Rezoning Transportation Analysis

Petition Number: 2023-037

From: Jake Carpenter, PE
Jacob.carpenter@charlottenc.gov
980-221-5675

Date	Description
7-26-23	First Review (IW)
8-24-23	Second Review (NK)

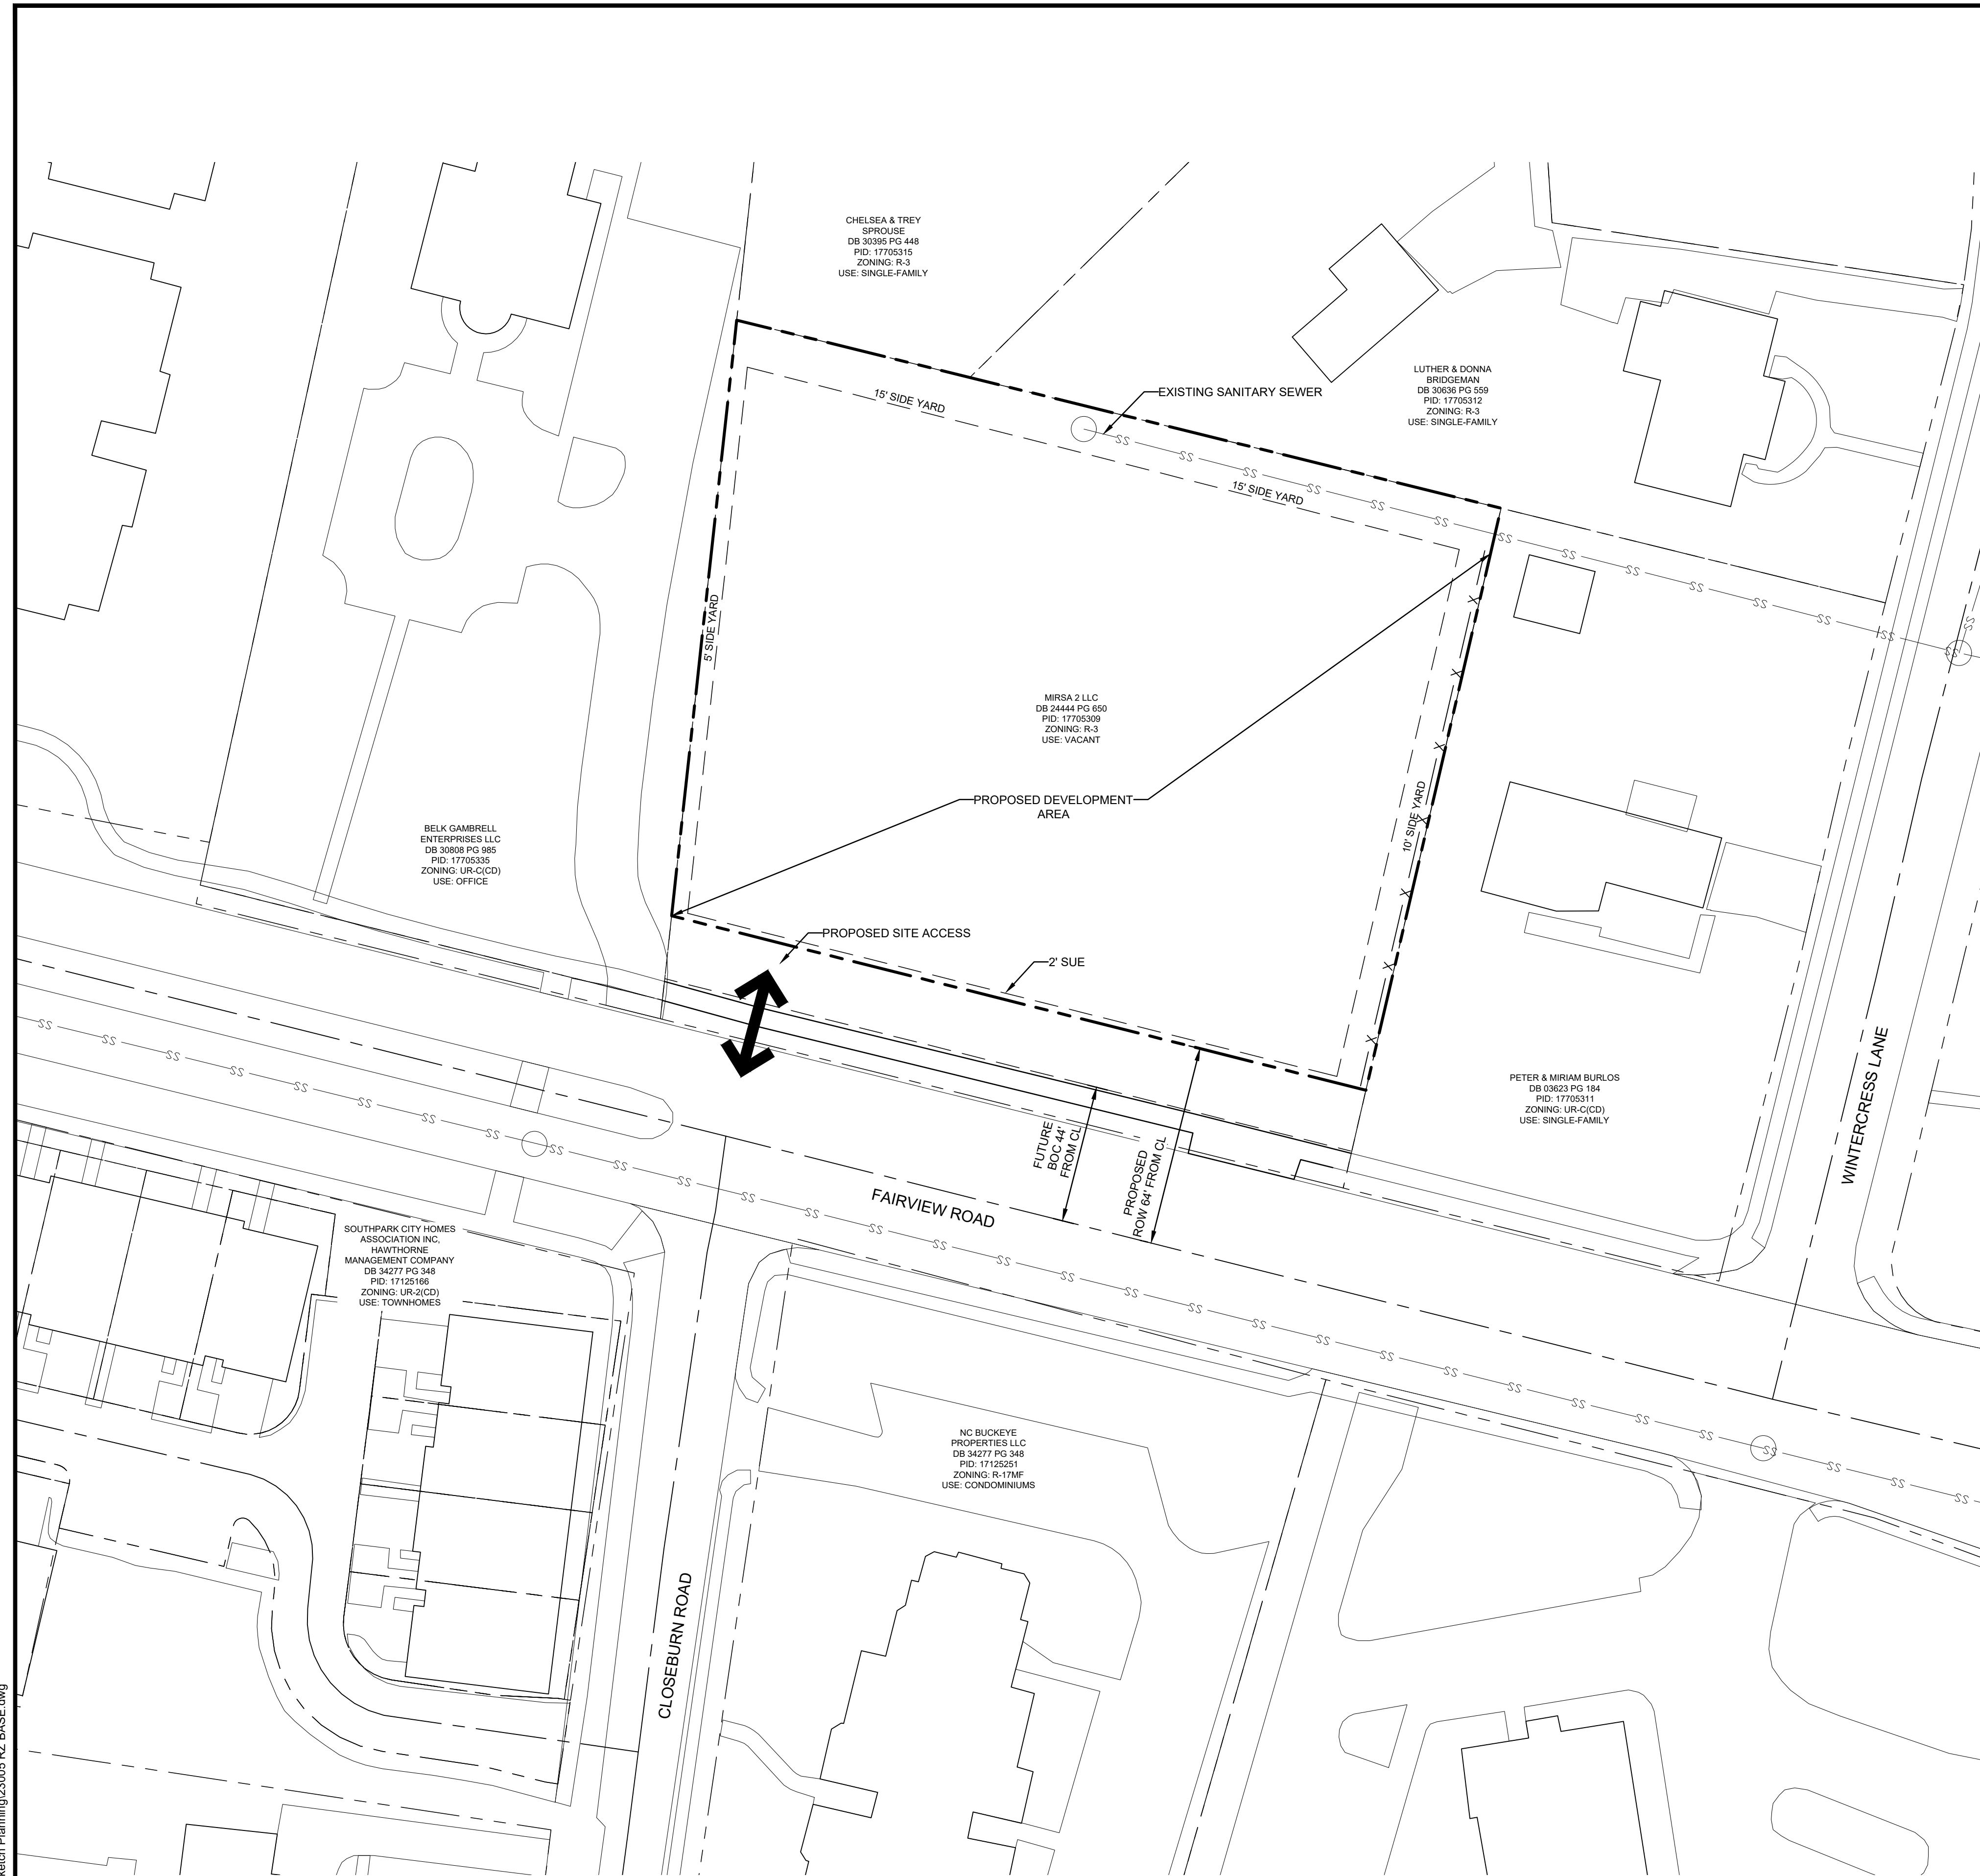
~~**Fairview Road:** Show future location of back of curb and gutter to be 44 feet from roadway centerline to accommodate the Charlotte Streets Map~~

~~Label and dimension the curb and gutter from the centerline for each road on the site plan.~~
